Development Facilitation Team (DFT) – Review Comments

DRB Project No: PR-2022-007645 Date: 05/10/2023 Agenda Item: #7 Zone Atlas Page: J-10

Legal Description: [LOT 2 TRACT S-1, UNIT 2, ATRISCO BUSINESS PARK]

Application For: SD-2023-00053-PRELIMINARY/FINAL PLAT (DHO)

Detail for Easement 8

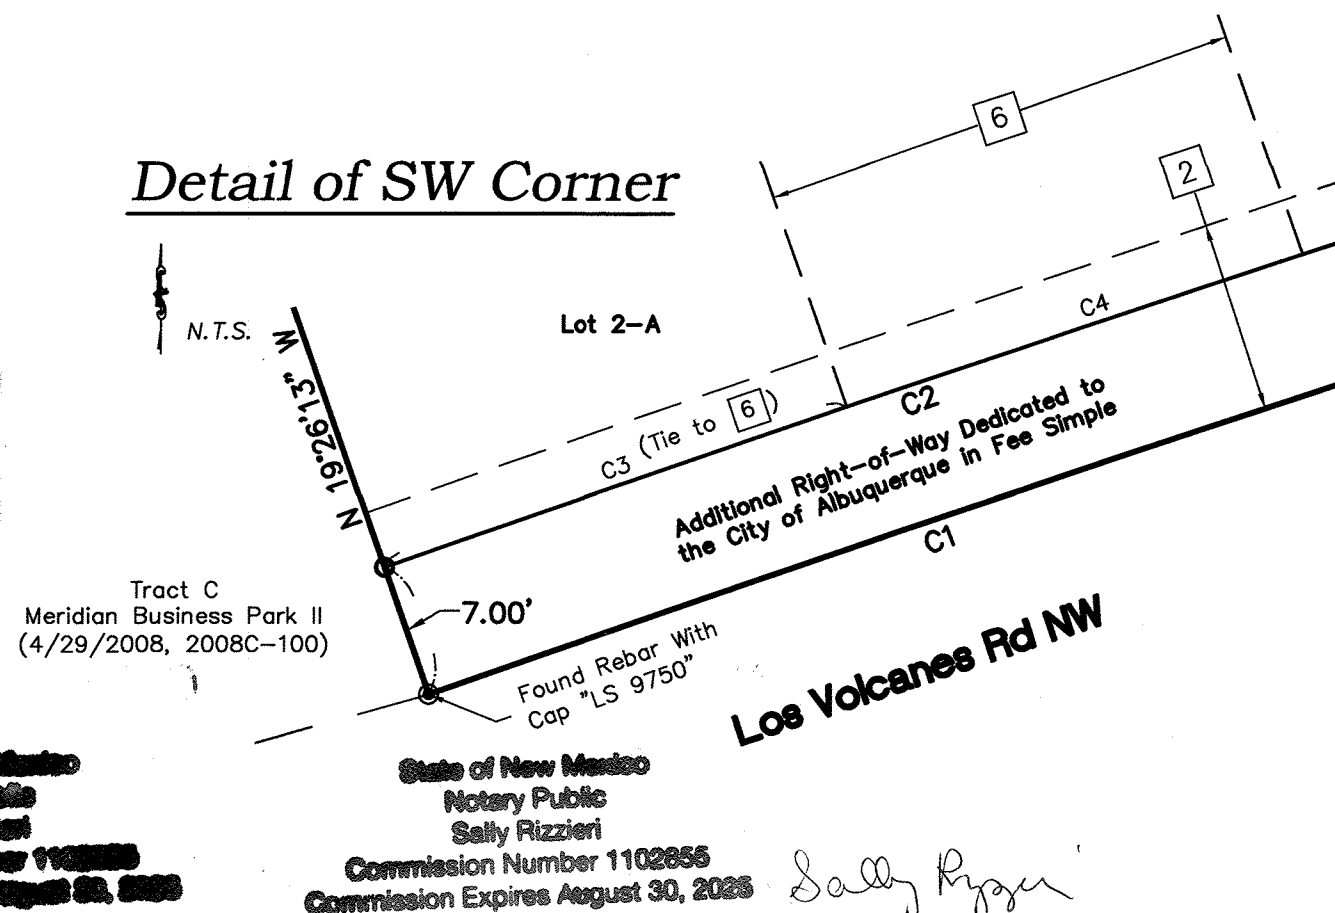
- Hydrology has an approved Conceptual Grading & Drainage Plan (J10D027) with engineer’s stamp 02/21/2023.
- The existing detention pond needs to be in a private drainage easement **with the drainage easement notes** showing maintenance responsibility for all three lots.
